Re: Response to submission re: MP 11_0009 Mod 1 – Miranda Dental Hospital

I refer to the e-mail submission lodged by Sutherland Council dated 10/01/2013 in relation to the S75W application to modify the project approval MP 11_0009 for a dental hospital at 84-86 Kiora Road, Miranda. We provide the following response to the four (4) key areas of concern identified by Council.

EAST & NORTH ELEVATIONS

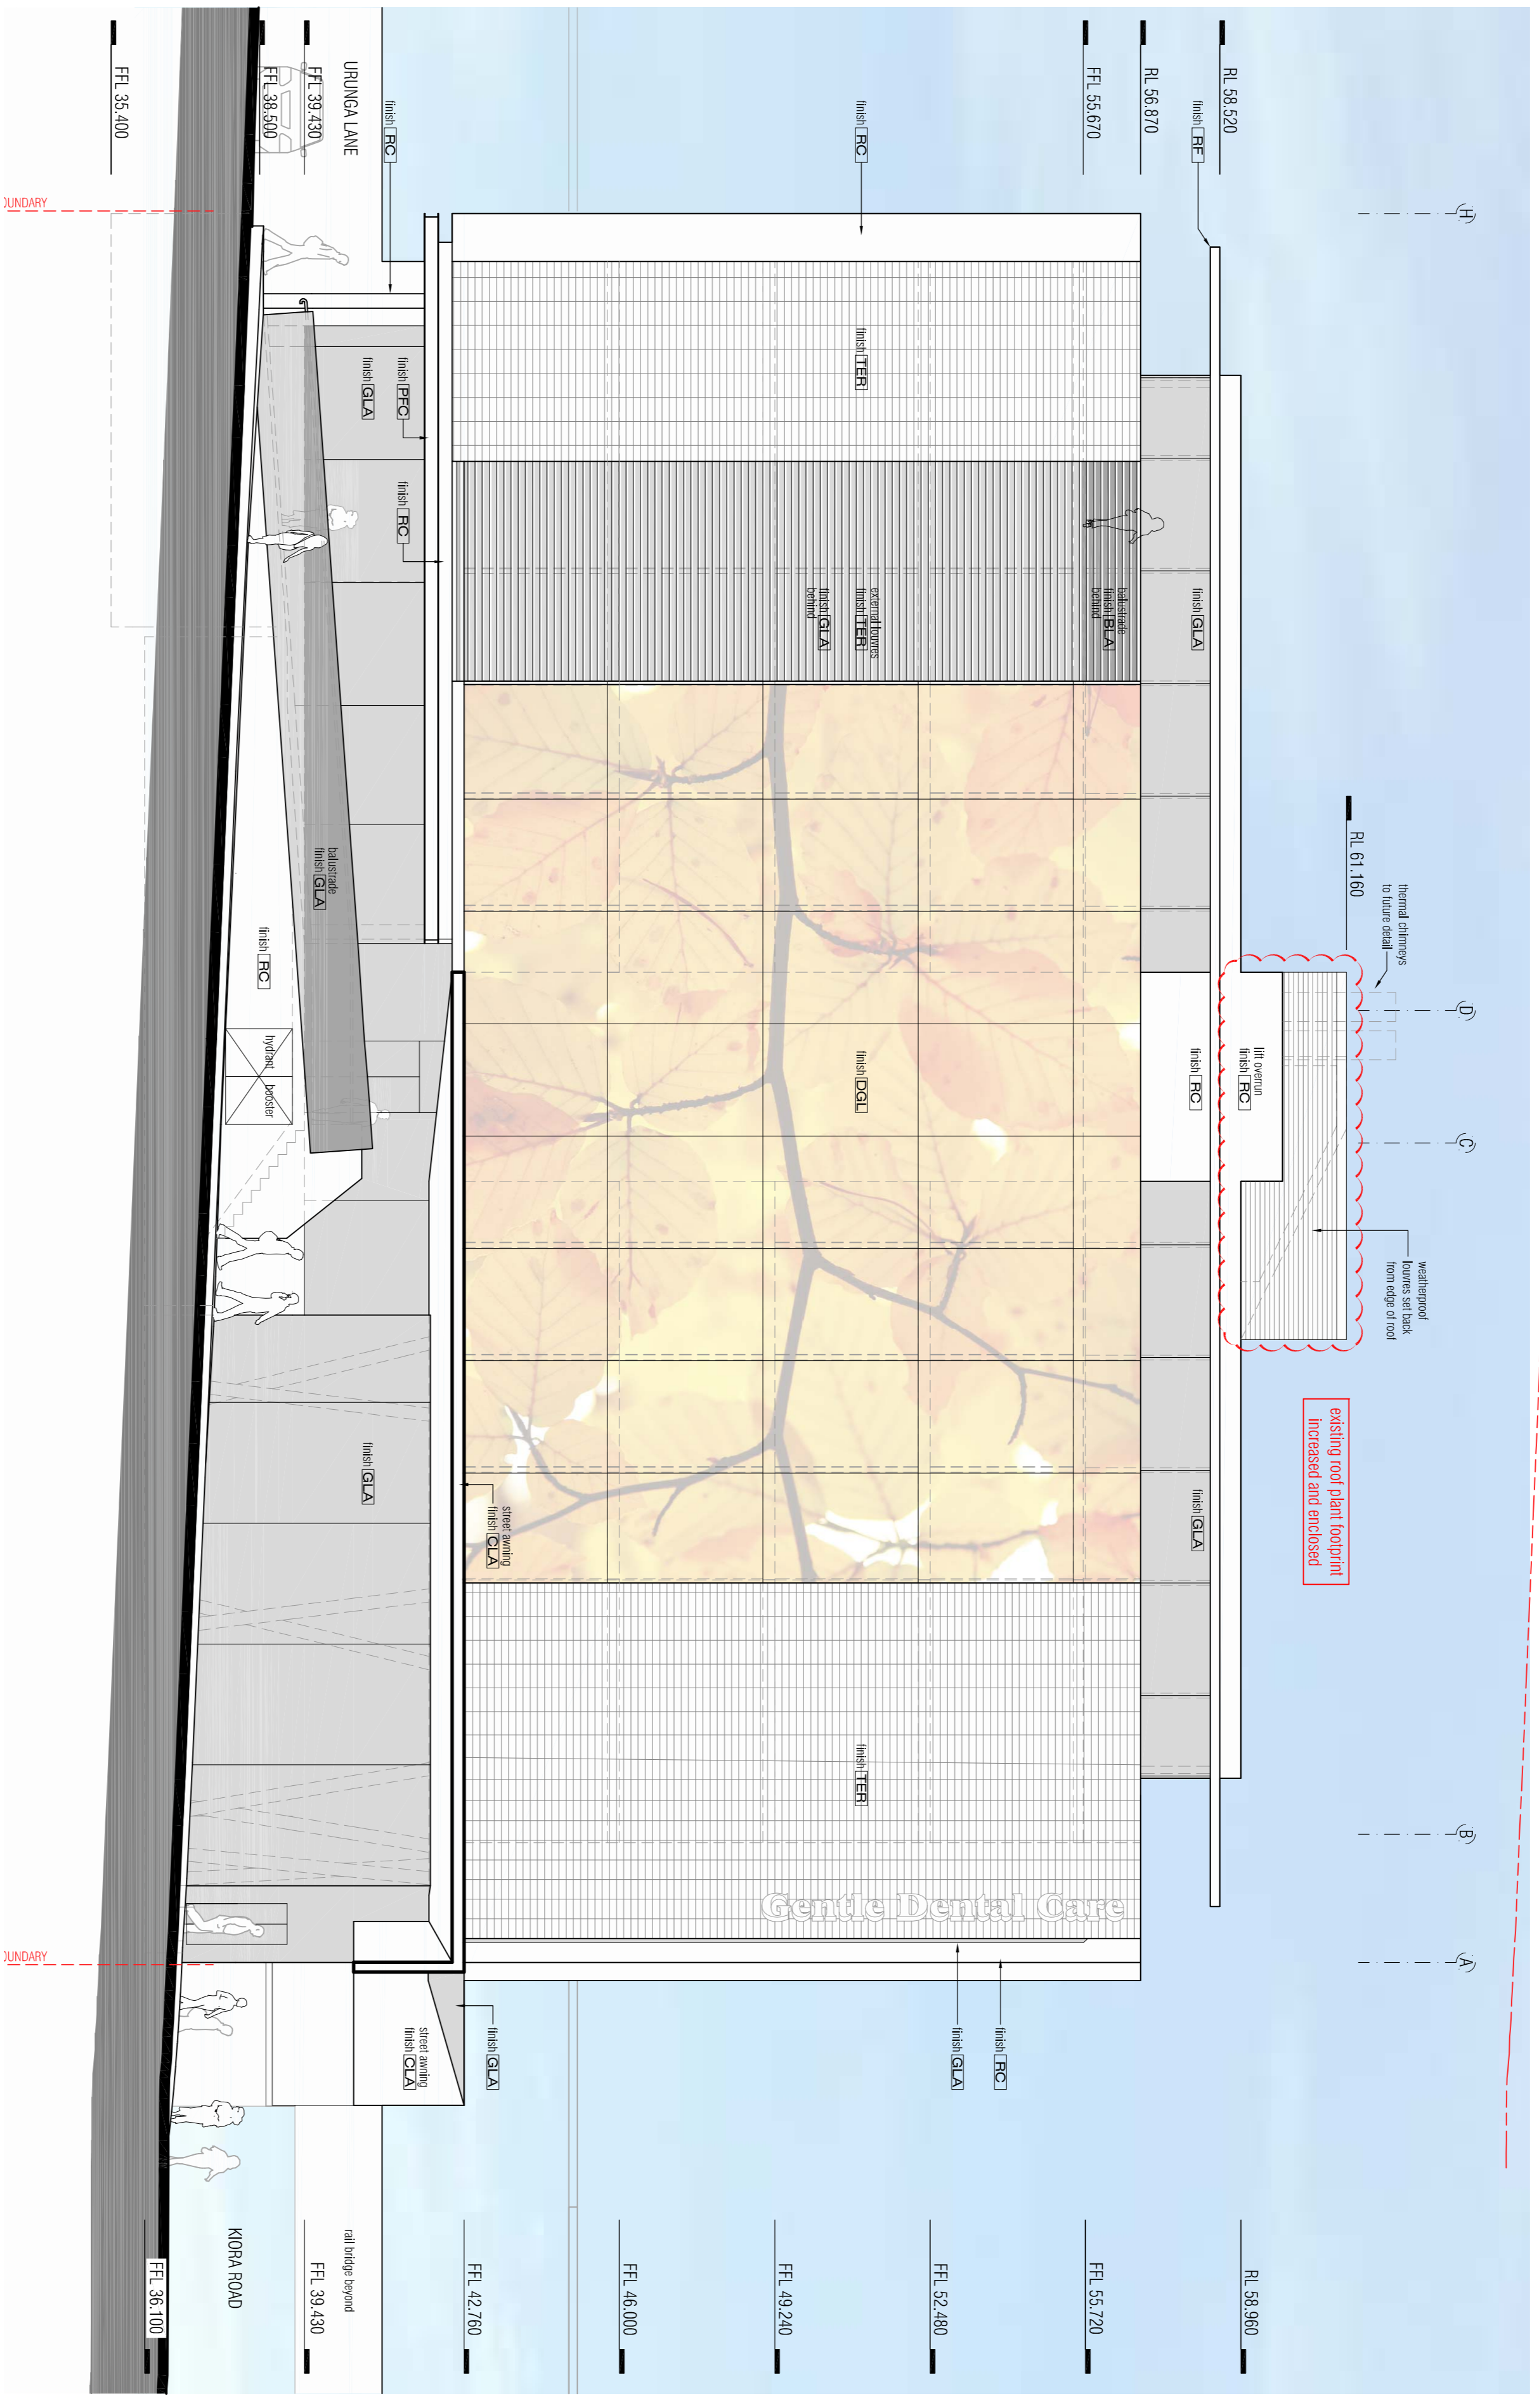
The information provided states that the plant will be setback and screened, however, no plans were provided. The roof top will be visible from the vantage points in tall buildings nearby and care needs to be taken to ensure that it is not unattractive.

The roof top plant room has been increased in overall size and height to accommodate the relocated plant equipment.

As indicated in the S75 application, the plant room is to be enclosed with

"weather proof louvres" as detailed in Architectural Drawings 2.05, 3.01, 3.02, 3.03 4.01 & 4.02 lodged with the S75W application.

Importantly, the plant room will be set back from the edges of the building and will not be generally visible from the public domain.
